SOUTH ACADEMY BUSINESS CENTER

FILE NO.
PCD 17-004

SOUTH ACADEMY BUSINESS CENTER
4425 HWY 85-87
EL PASO COUNTY, COLORADO
SITE DEVELOPMENT PLAN

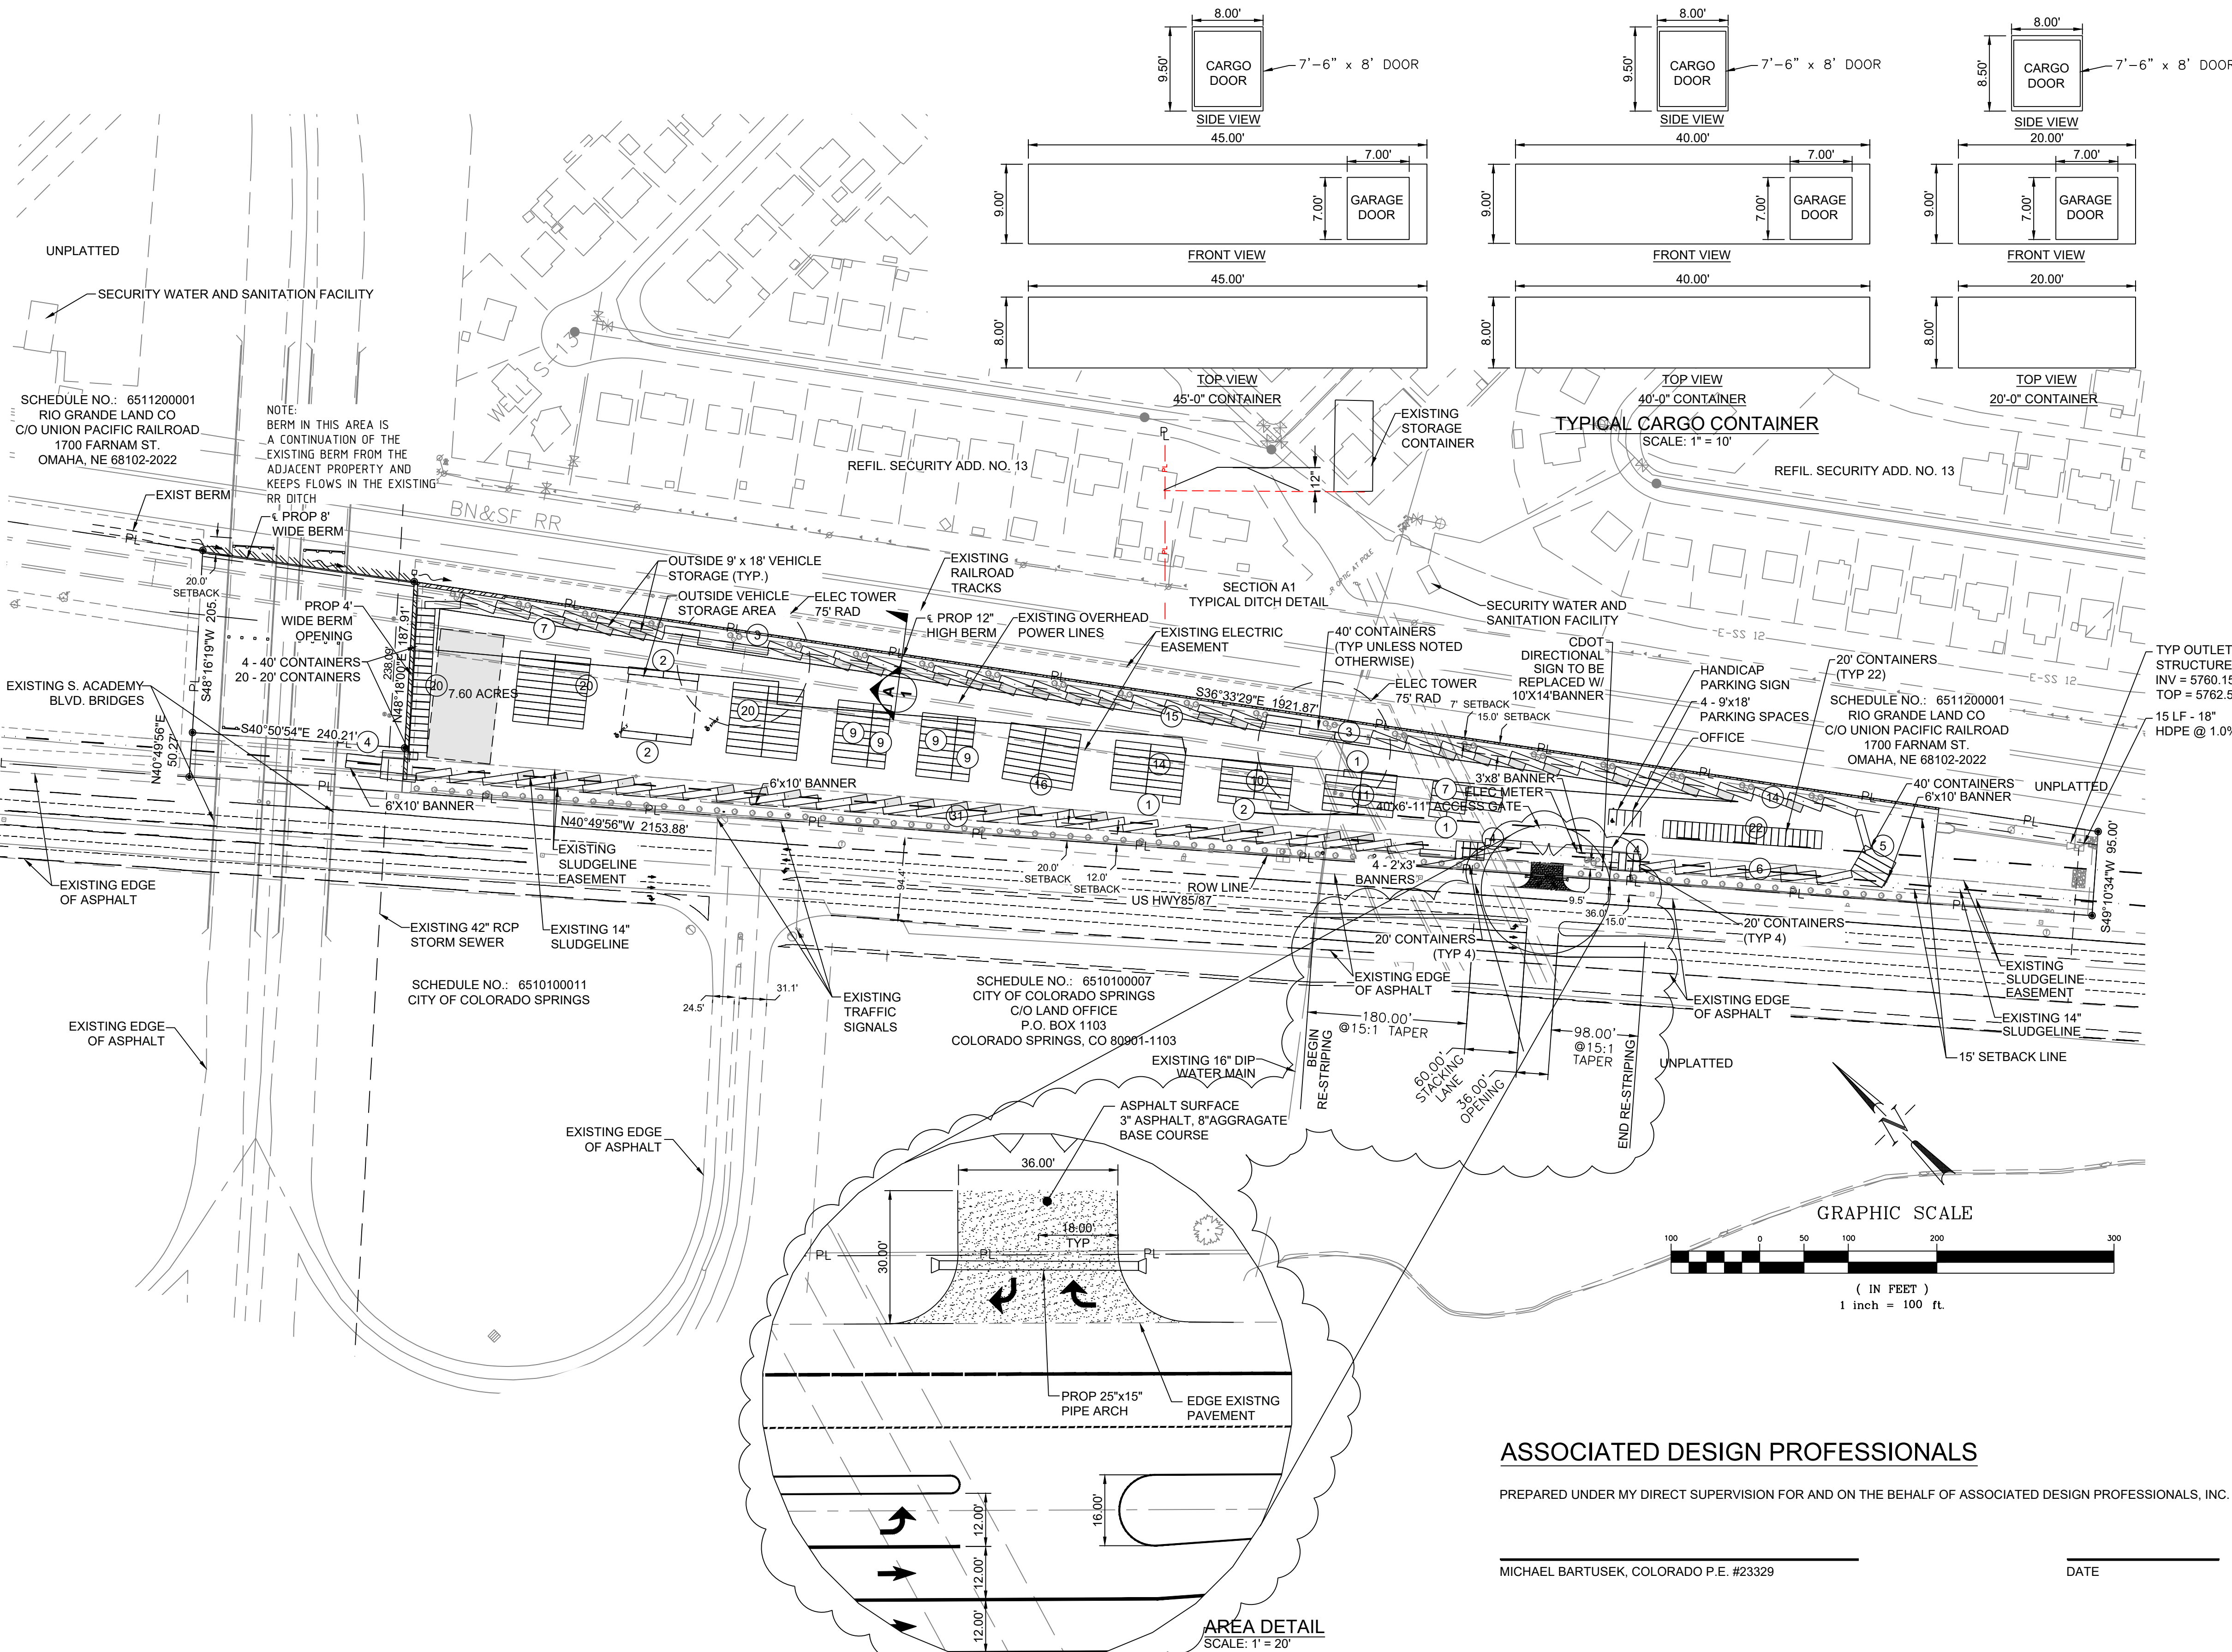
All of these storage units should be 15 feet away from the property line unless an additional process is applied for.

The drive aisle shall be 24 feet when both sides of the road have access to units. If only one side of the road has access to storage units the drive aisle can be 20 feet wide.

The drive aisle shall be 24 feet when both sides of the road have access to units. If only one side of the road has access to storage units the drive aisle can be 20 feet wide.
